**STAGE 1 SHEPHERDS BAY
RESIDENTIAL**

ACCESS REVIEW

Morris-Goding Accessibility Consulting

6 August 2012

Building Name : STAGE 1 PROJECT APPLICATION (MP 09_0219)
Drawing Title : UPPER BASEMENT PLAN

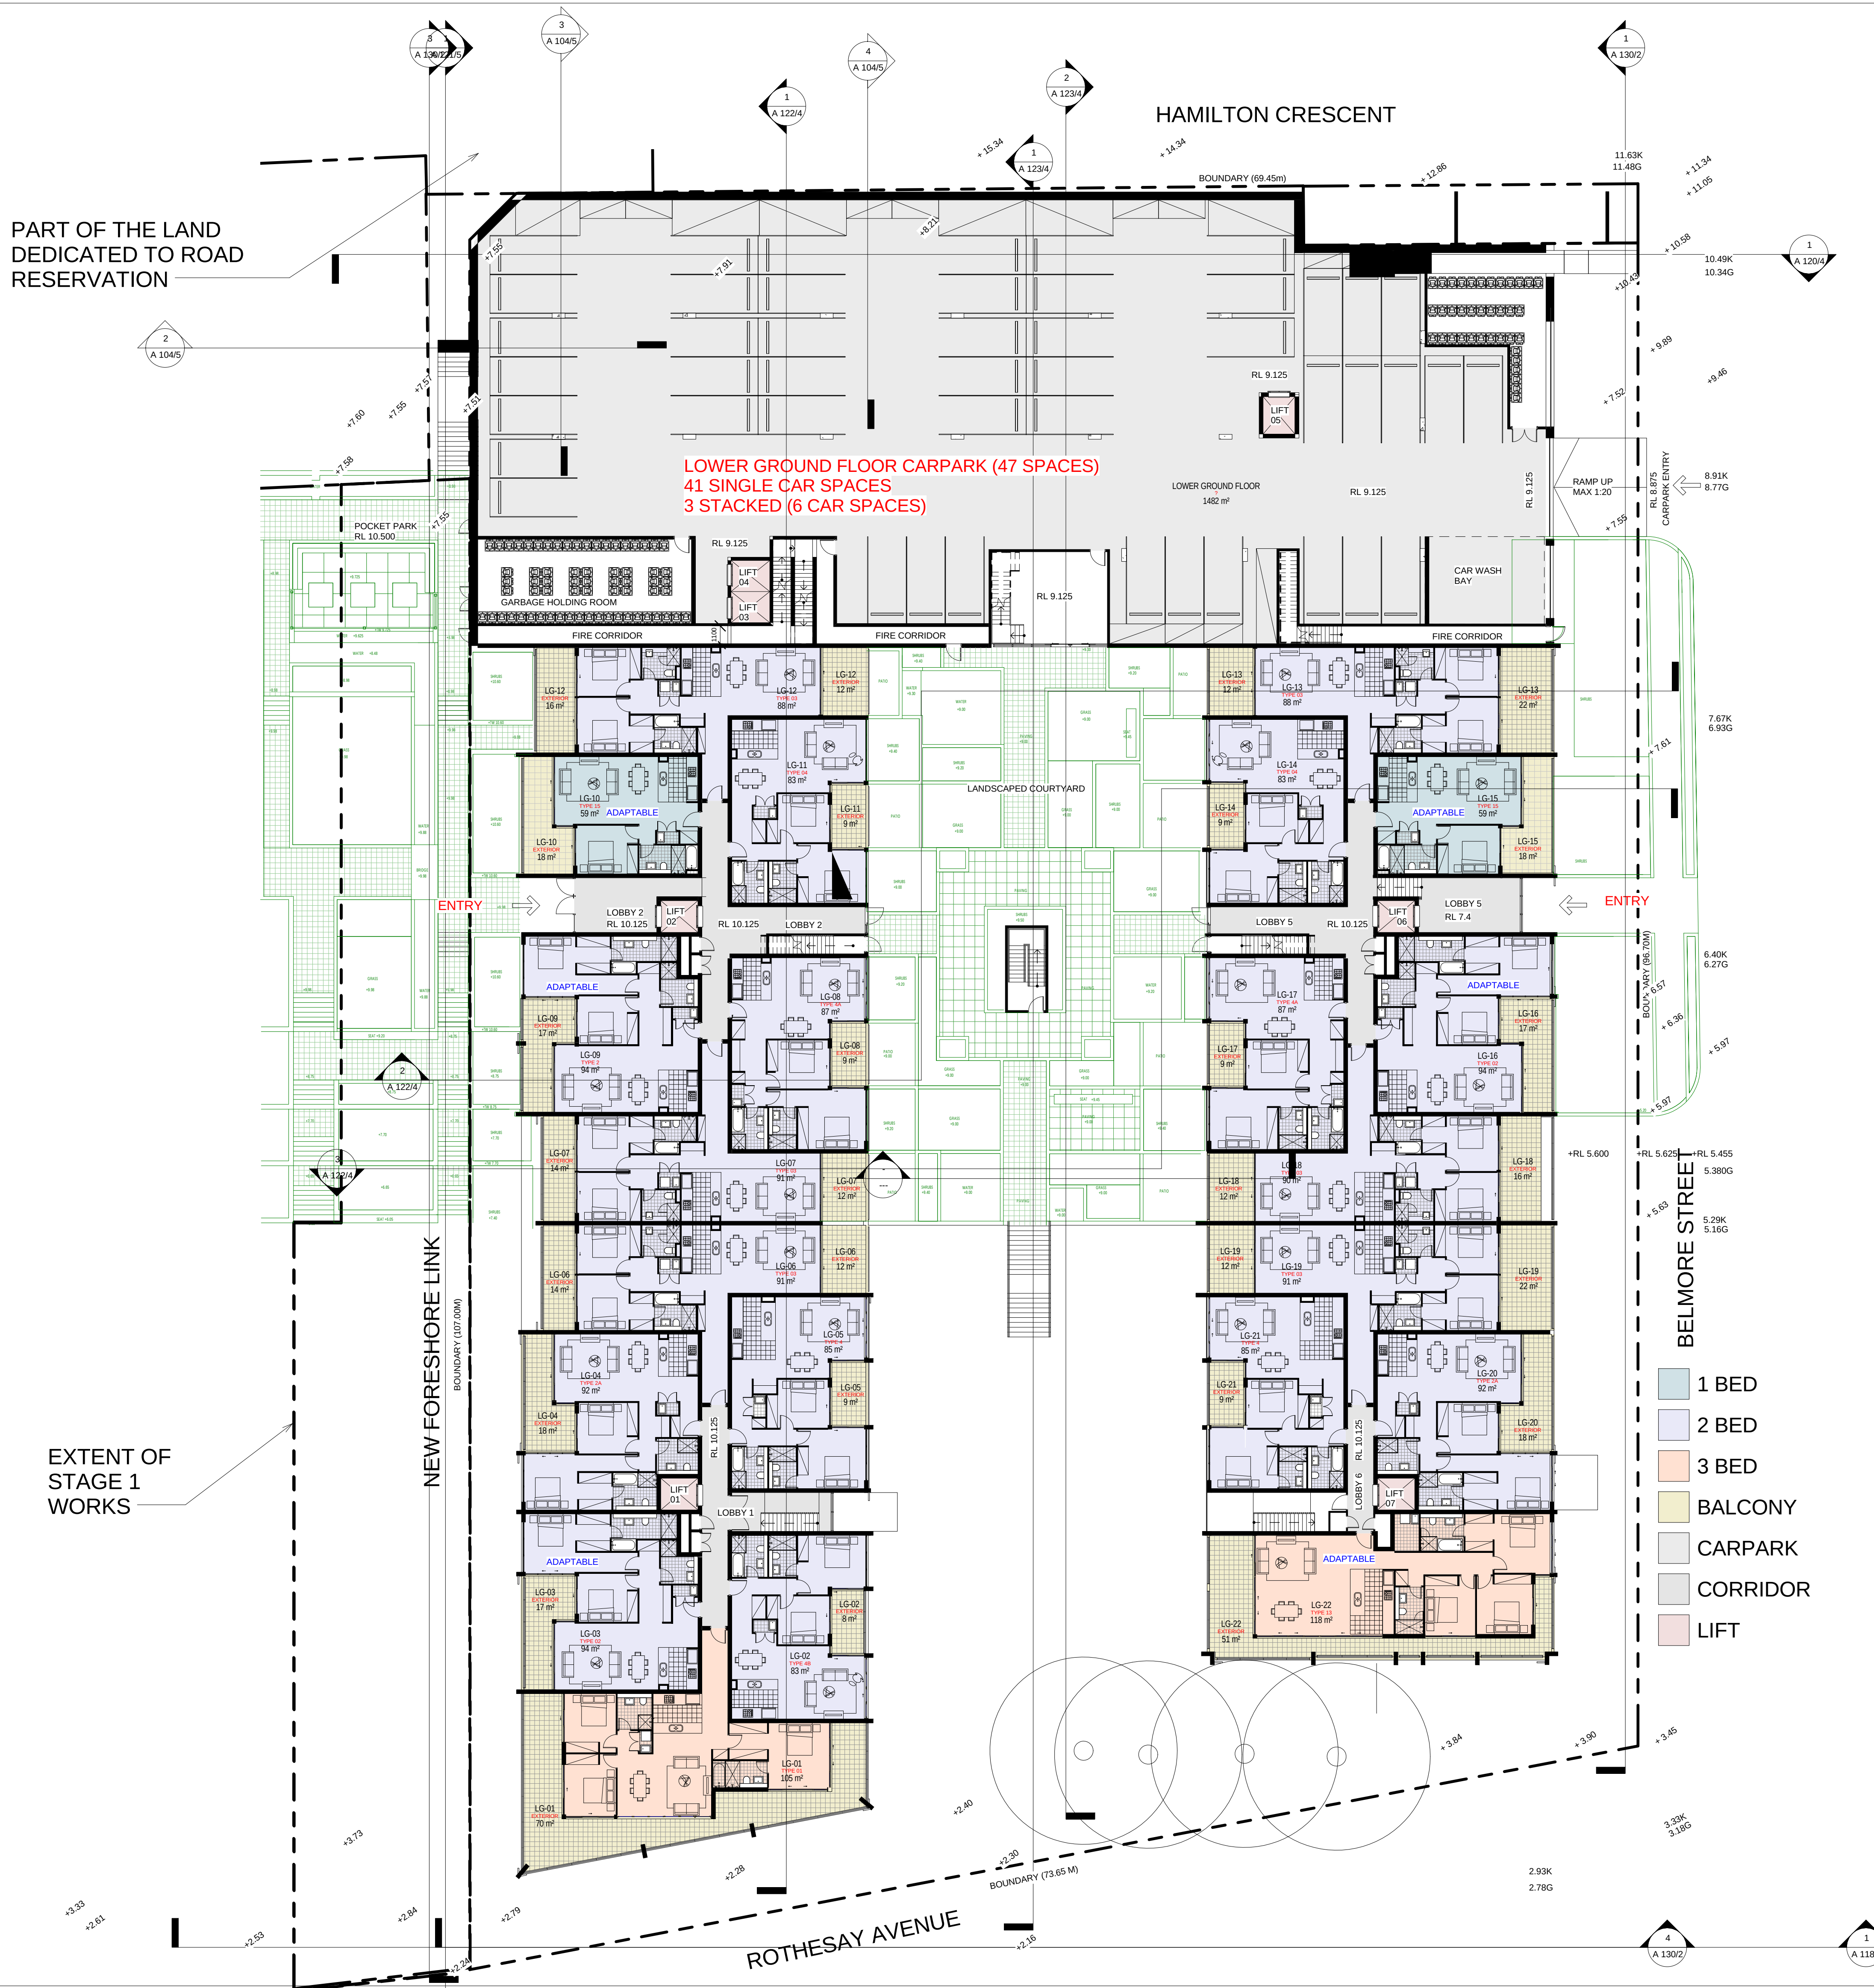
Lifts 1 & 7 can access the garbage holding rooms on basement level. However the garbage room adjacent lift 7 has a 1:12 ramp.

Lifts 2 & 6 can access the garbage holding rooms on upper basement level.

- (i) Garbage holding room doors are to have a clear width of 850mm appropriate for wheelchair users.
- (ii) The ramp will require 1:14 gradient under A1428.1.

UB - 04,UB - 09,LG - 10,LG - 15,

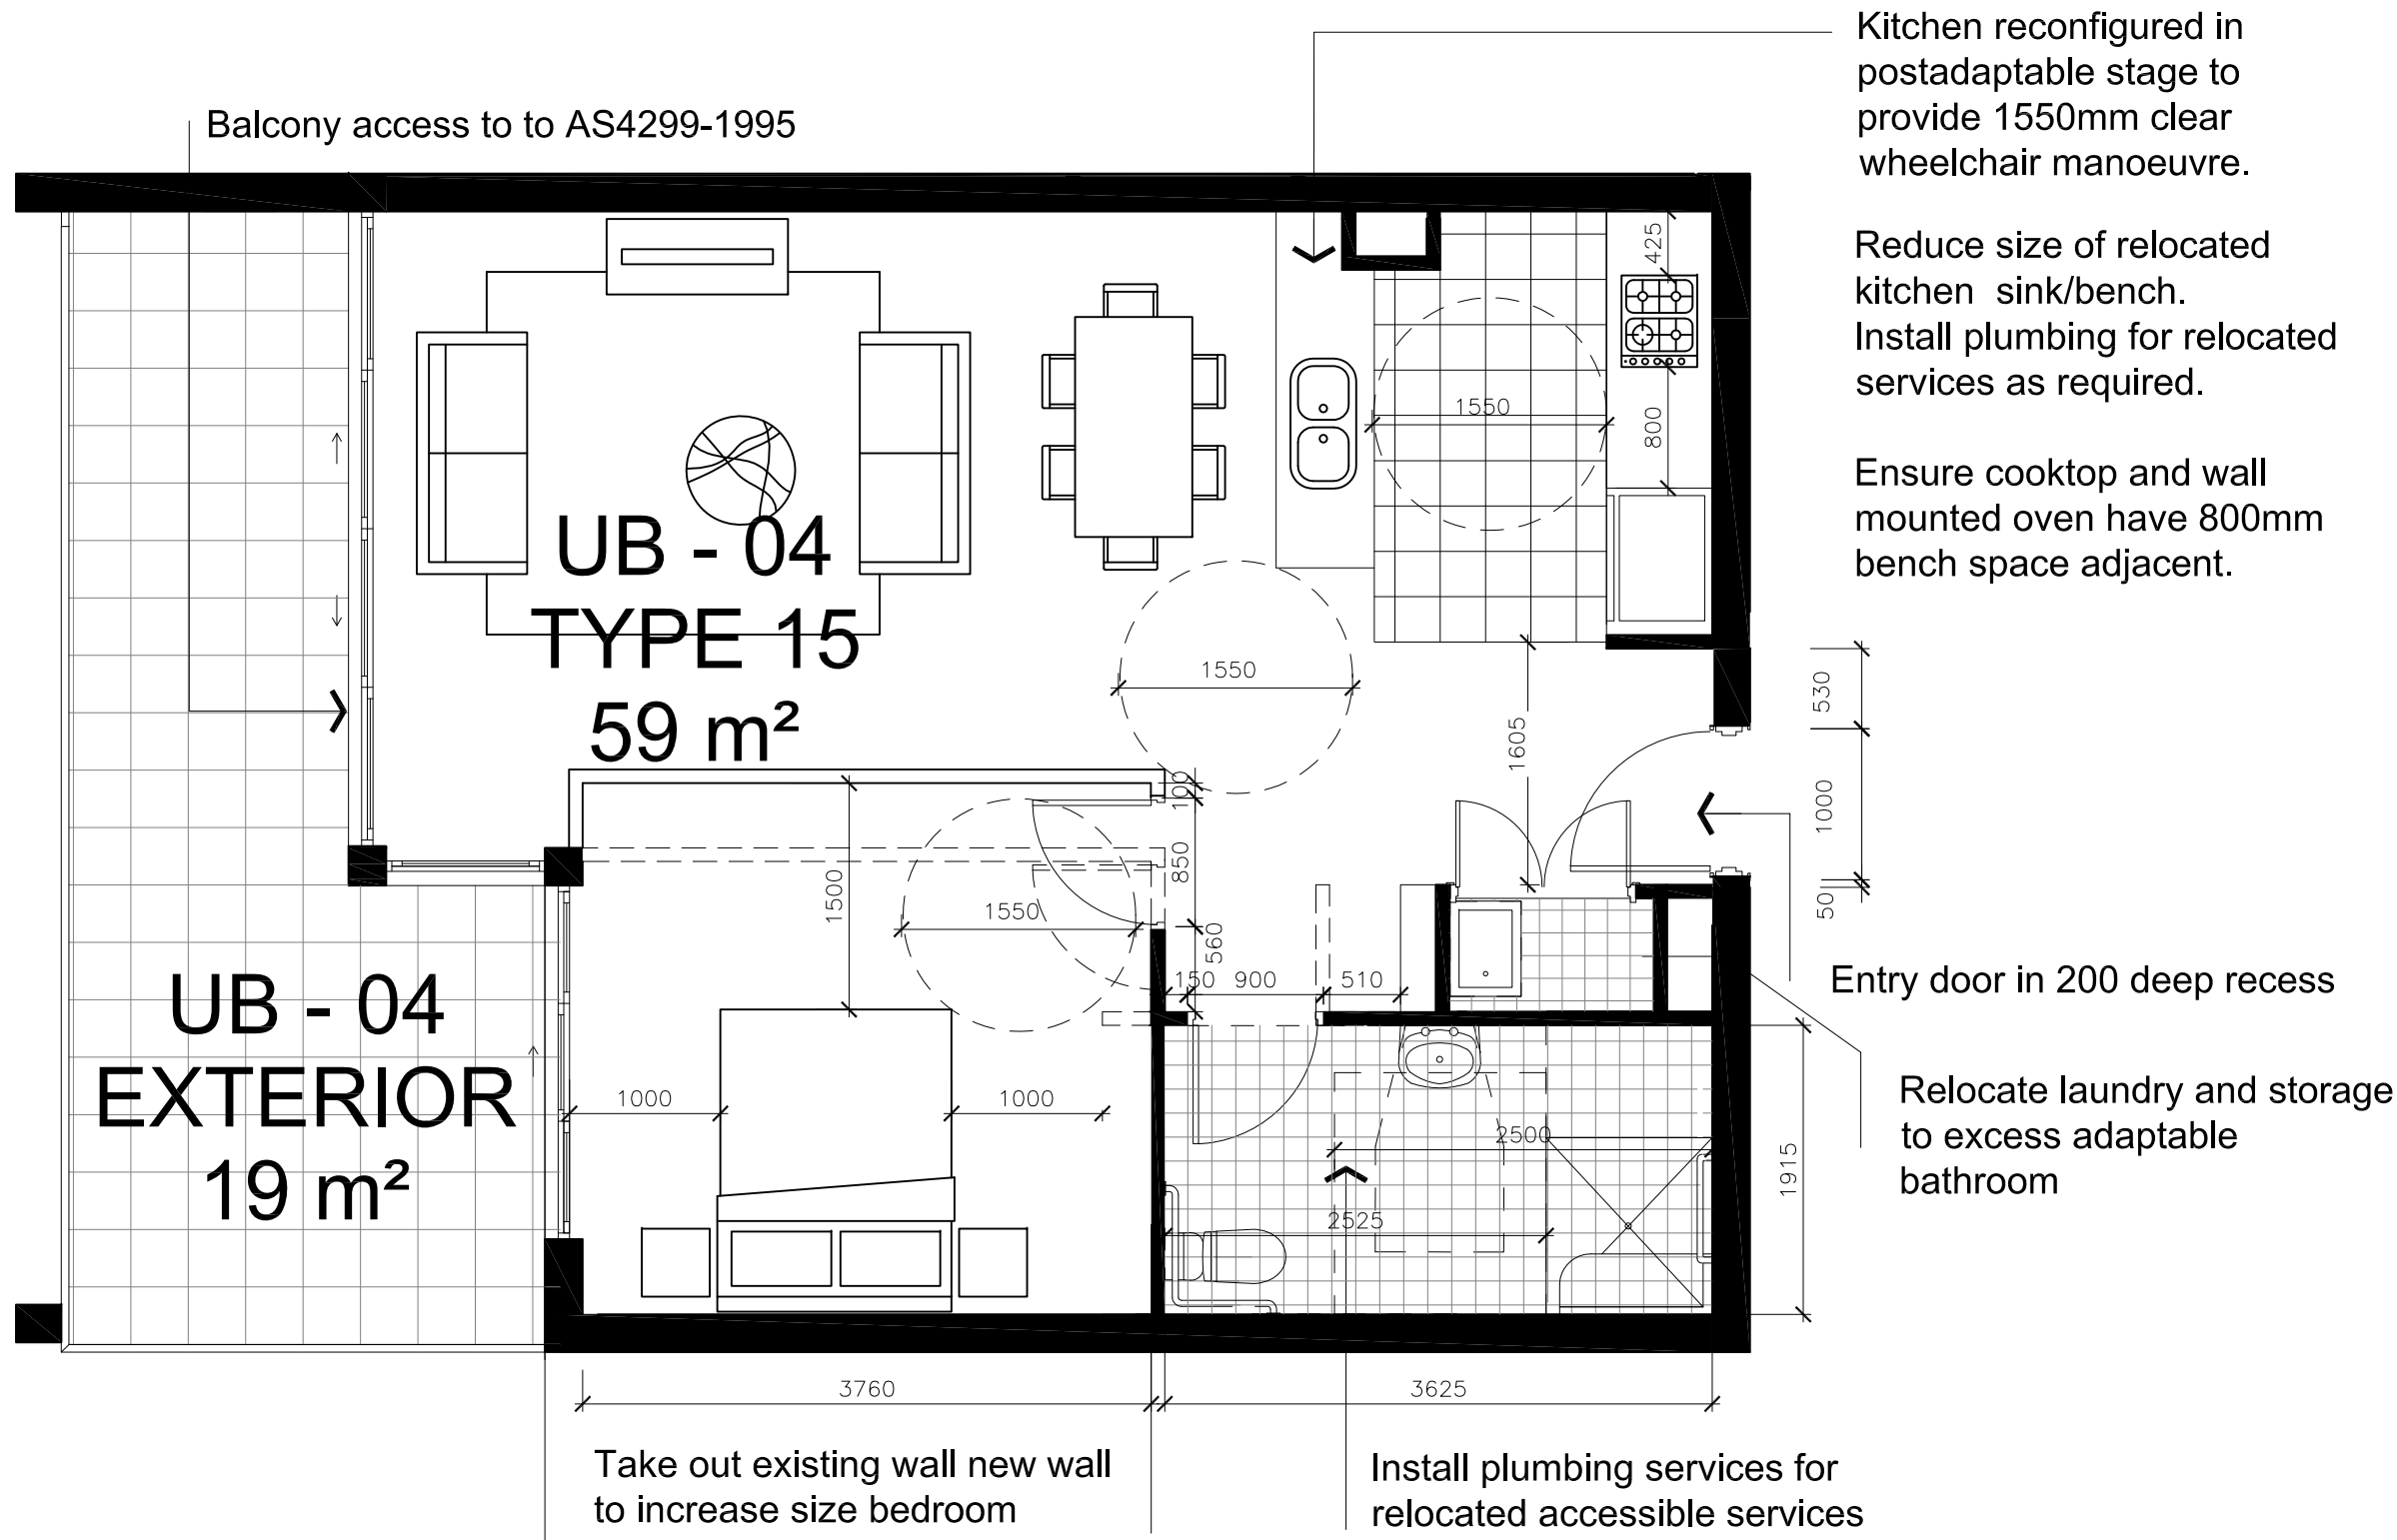
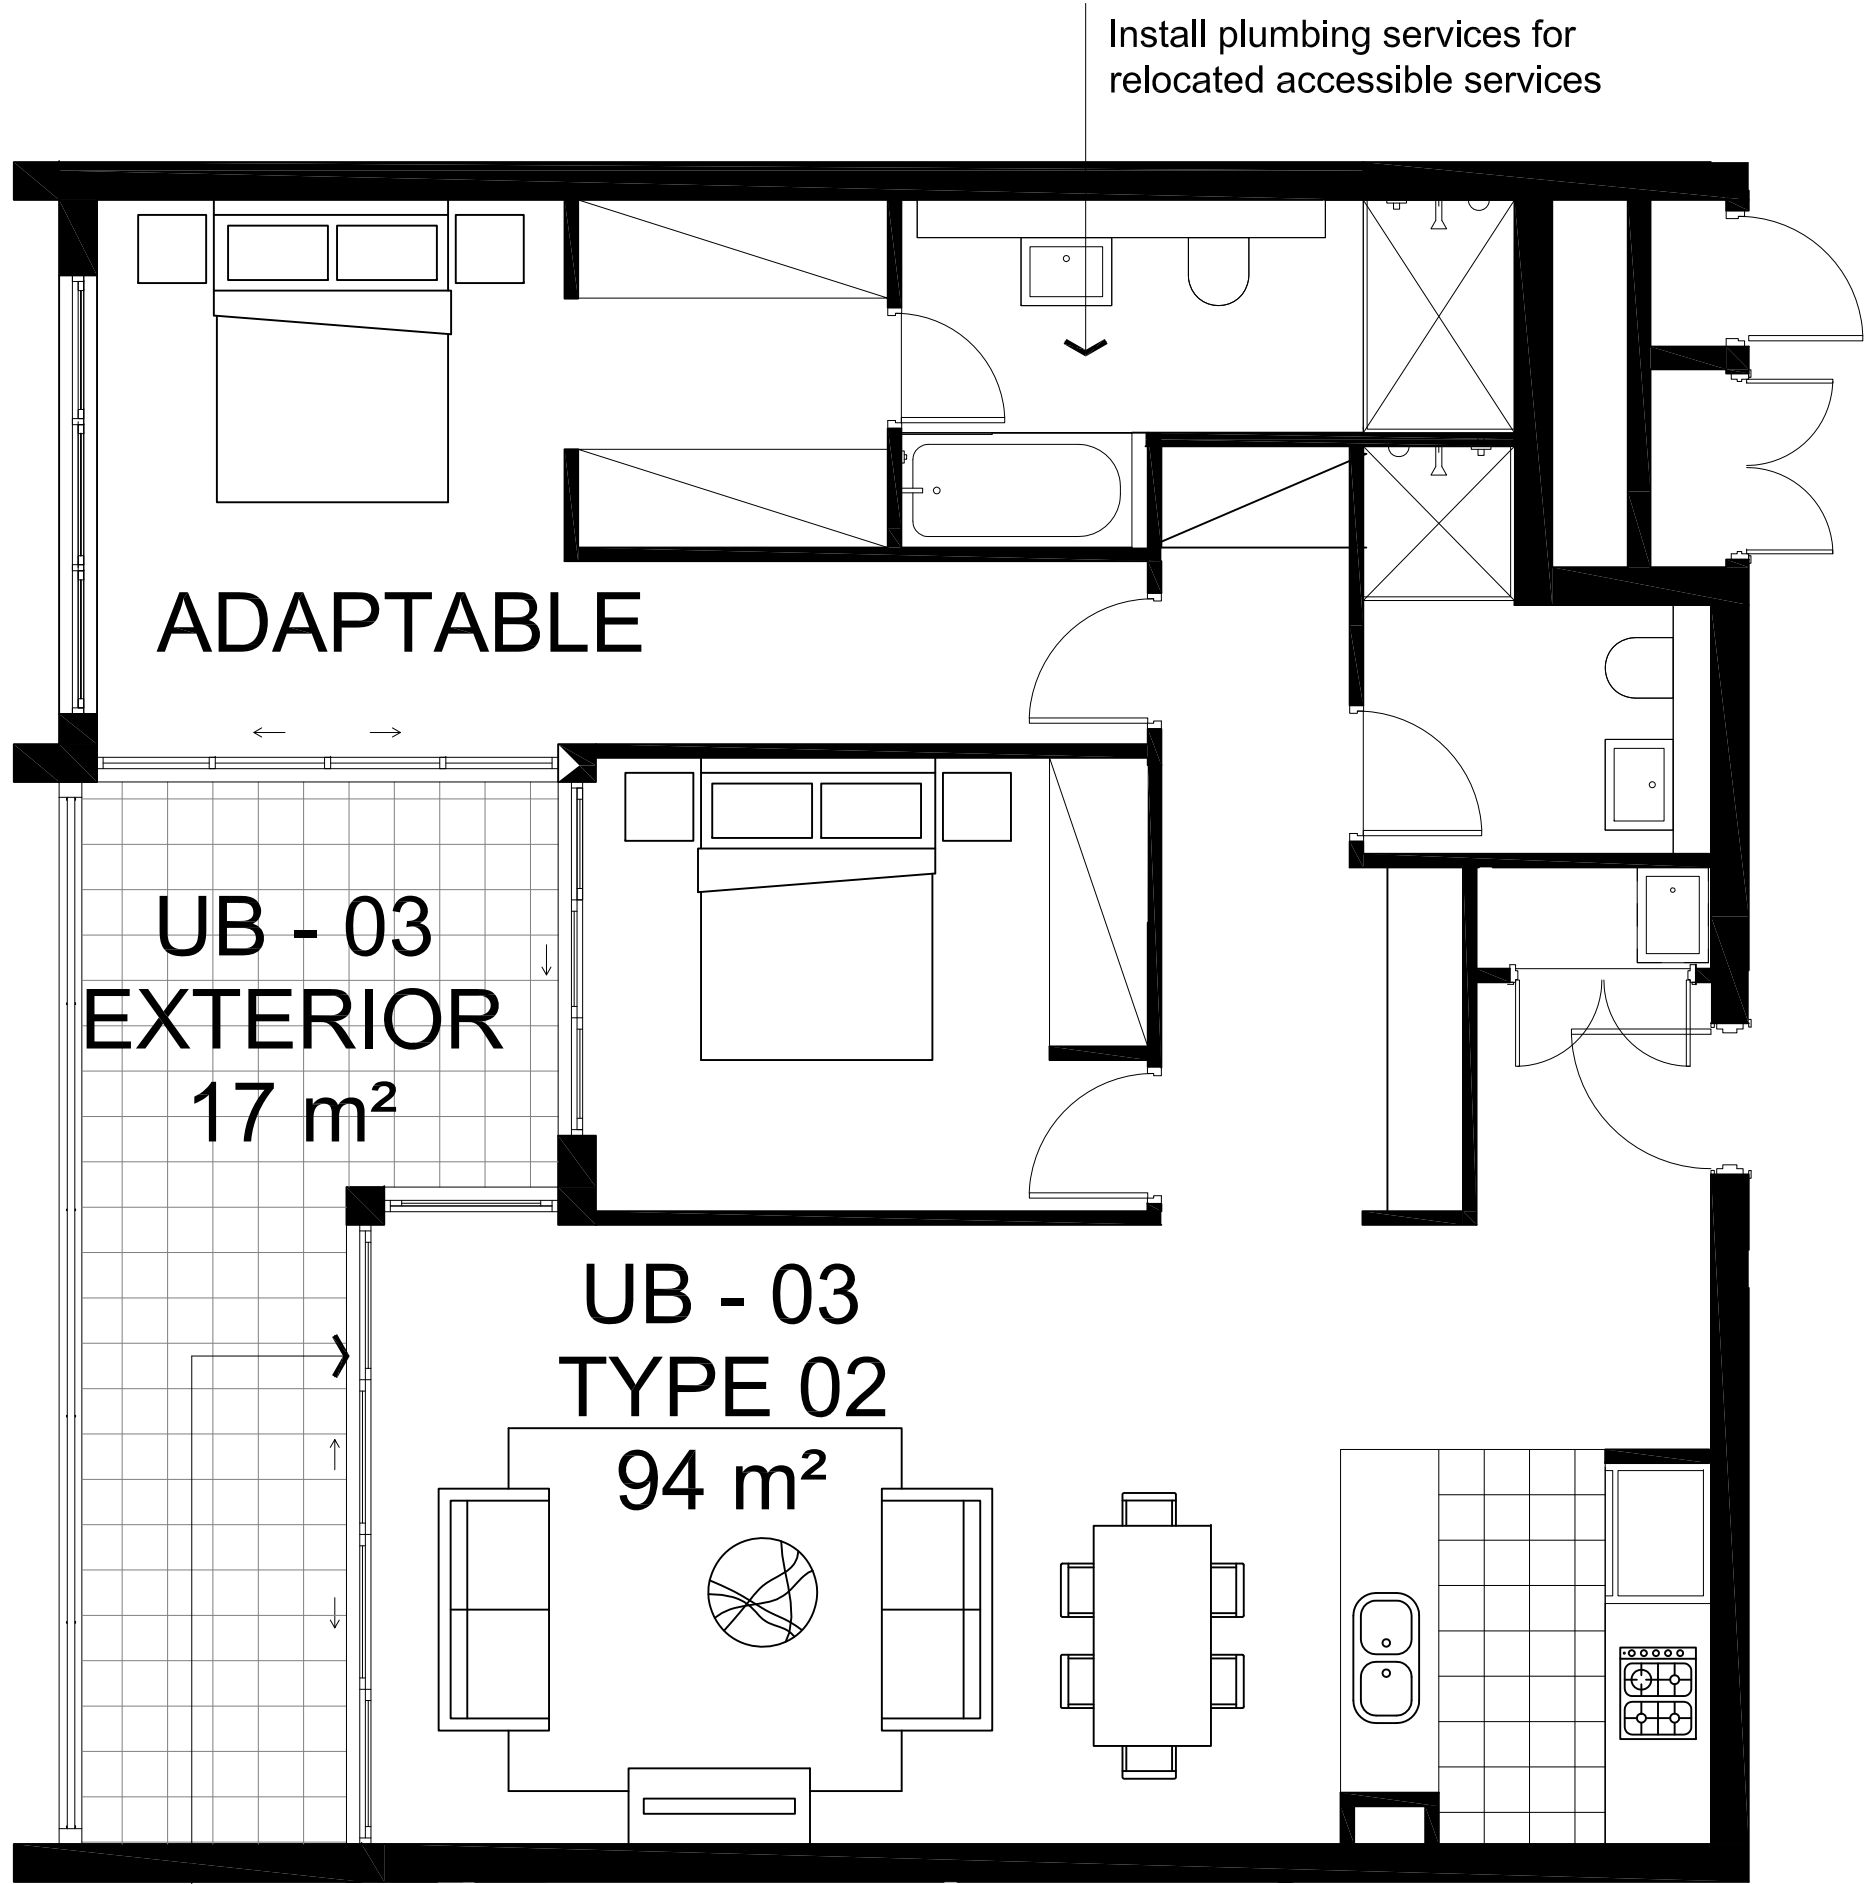
The shared bathroom and bedroom wall is to be relocated at post-adaptation which will require retiling and waterproofing. Bathrooms are to have internal dimensions with circulation areas to cater for pan, basin and shower in accordance with AS1428.1:2009 at pre-adaptation stage. Drawings are to show post-adaptation layouts with capped off services as required in pre-adaptation drawings to achieve the circulation requirements in compliance with AS1428.1. The en-suite will need to be enlarged.

The bedroom area can achieve suitable 3600mm x 3600mm outside the robe area compliant with AS4299.

- (i) Bathroom (shower, toilet, wash basin) to comply with circulation area requirements of AS1428.1, that is provide an area of 2300mm x 1900mm around the pan. The wash basin should sit outside this area, and if needed only encroach into this area by 100mm (max). In general, the bathroom should be 2750mm x 2300mm (min).
